## Subdivision Comments

From: Jesse Cox, Environmental Health Supervisor  
Erin Moore, Water Resources Program Coordinator

Date: 03/06/2020

RE: LPF-20-00001

BIG CREEK - DIVISION I
A PORTION OF THE N 1/2 OF THE SE 1/4 OF SECTION 29,
TOWNSHIP 20 NORTH, RANGE 14 EAST, W.M.
KITTITAS COUNTY, WASHINGTON

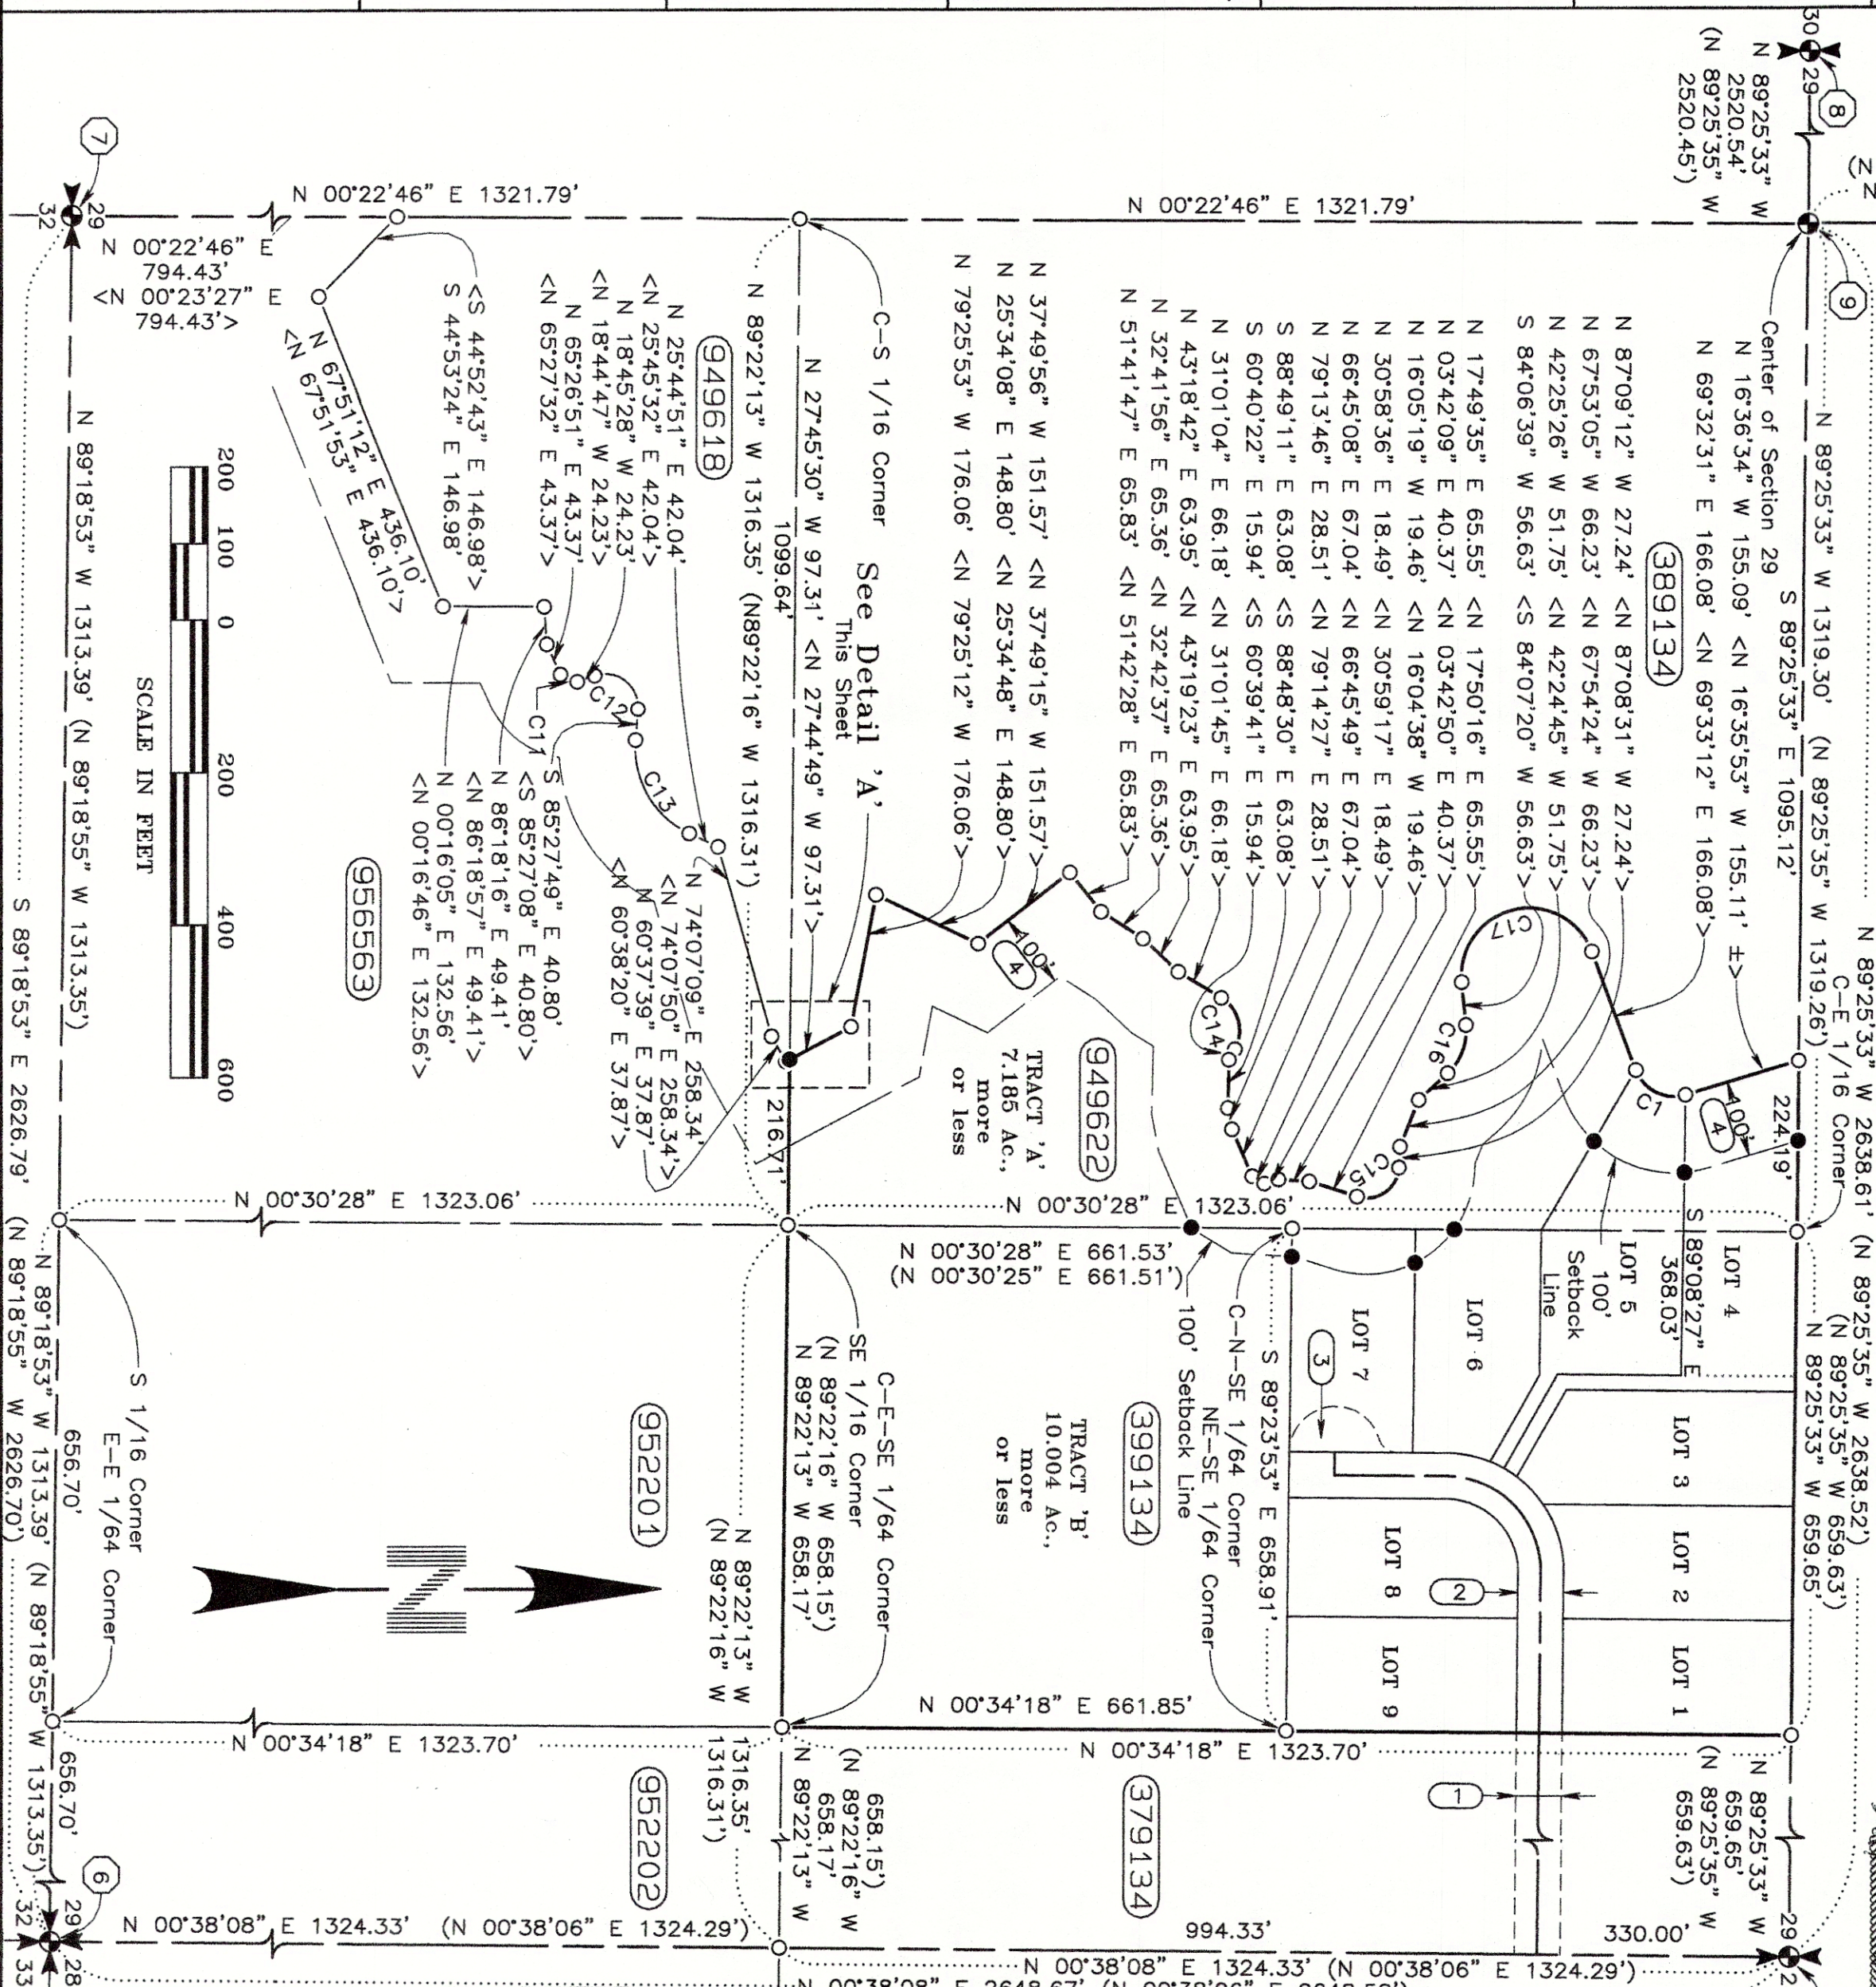
The following notes shall be placed on the face of the plat:

- C-1** “Metering is required for all new uses of domestic water for residential well connections and usage must be recorded in a manner consistent with Kittitas County Code Chapter 13.35.027 and Ecology regulations.”

- C-2** “The approval of this division of land provides no guarantee that use of water under the ground water exemption (RCW 90.44.050) for this plat or any portion thereof will not be subject to curtailment by the Department of Ecology or a court of law.”
